Date: 08 December 2020
Our ref: 334958
Your ref: TR030001 NMC

NSIP Reference Name / Code: The Able Marine Energy Park (AMEP) Development Consent Order 2014 – S.I. 2014 No. 2935

1. a non-material change to amend the certified drawings set out in Requirement 6 of Schedule 11 (Requirements) of the DCO to remove reference to Area A and to introduce a new drawing which identifies the new site at Halton Marshes; and
2. a non-material change to Schedule 1 to confirm that the ecological mitigation will be provided in accordance with the environmental monitoring and management plans but to reflect that the re-siting of Area A to Halton Marshes will be outside of the Order limits.

Drawing file: published-documents / TR030001-003455-Able NMC - Tab 3(1) - Substitute Plan - AME - 02006 C Indicative Masterplan.pdf

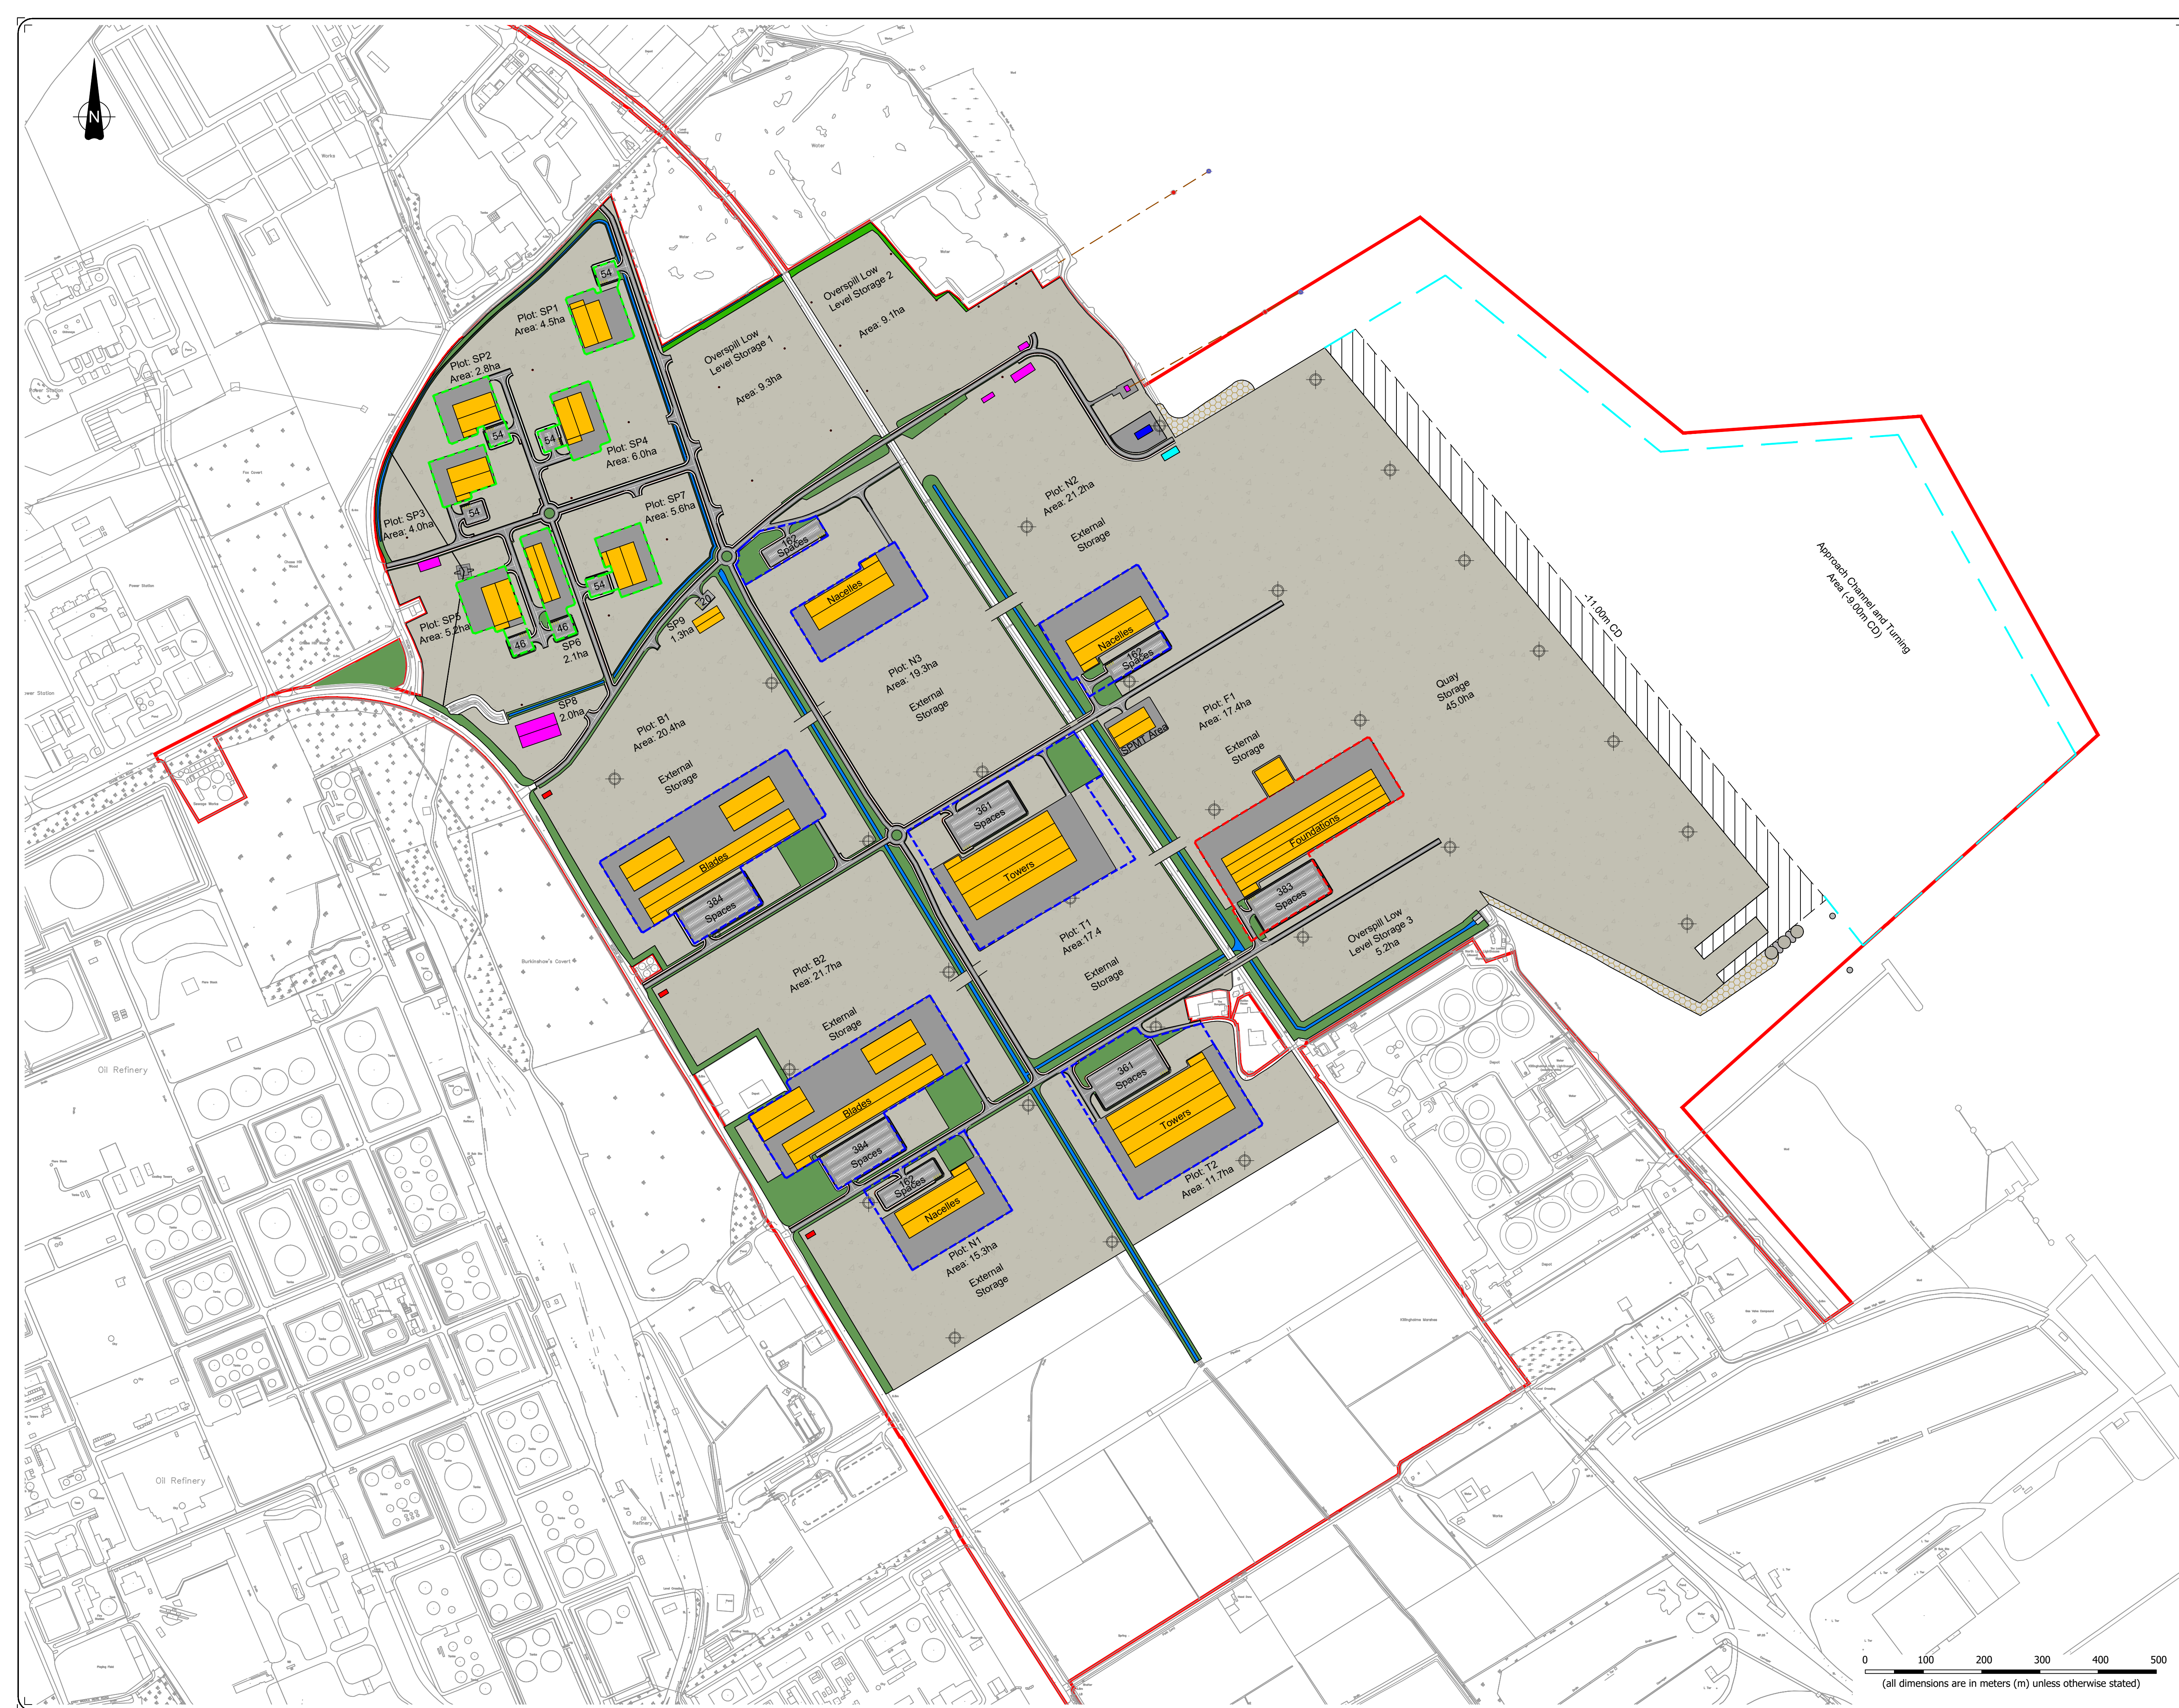
It is unclear why the red line boundary remains in the same location, although it is understood that this would now be removed from the DCO development limits. No further comment.
